| <b>Project Name</b>       | A47 Blofield to North Burlingham                     |
| <b>File reference</b>     | TR010040   |
| <b>Meeting objectives</b> | Project update meeting and review of draft documents |

### **Section 51 Advice –draft Application Document by Highways England for PINS review**

Figure 0-1:
Option 1

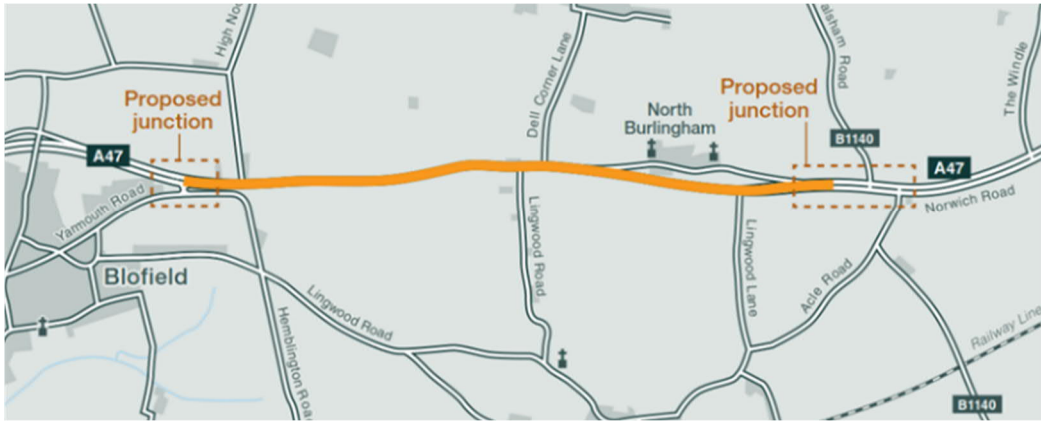
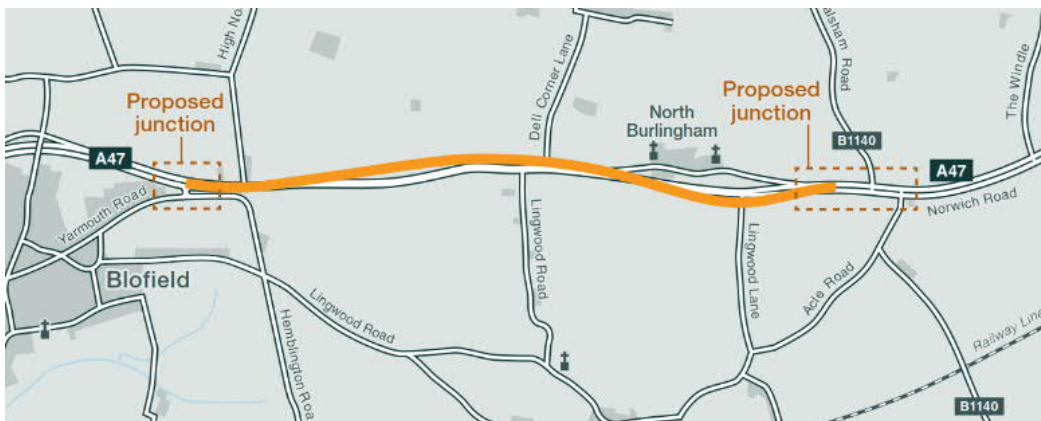
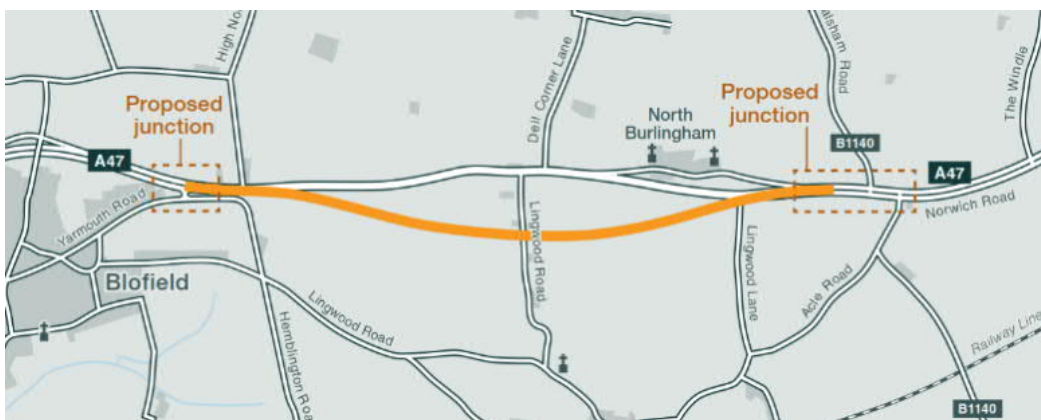
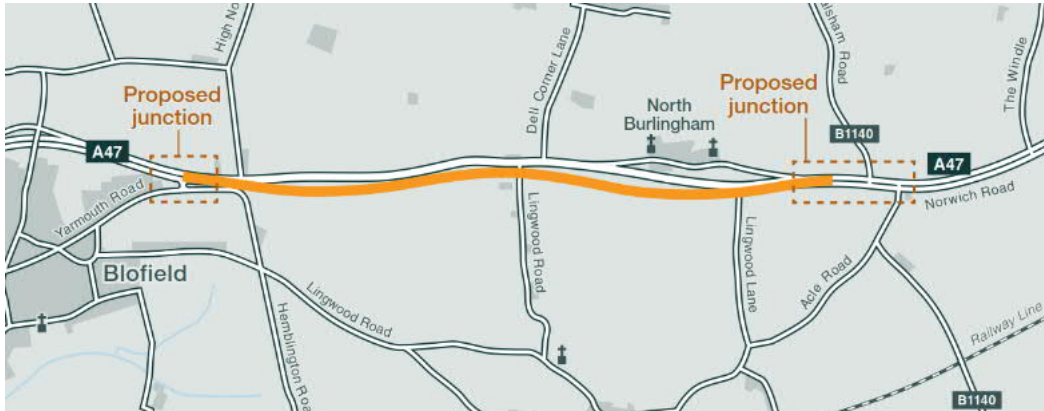
| 12. | Ch 3<br>3.2.13         | <i>Figures 3.1 to 3.4</i>  | The figures within the ES should be larger and include a scale to aid the reader.  |
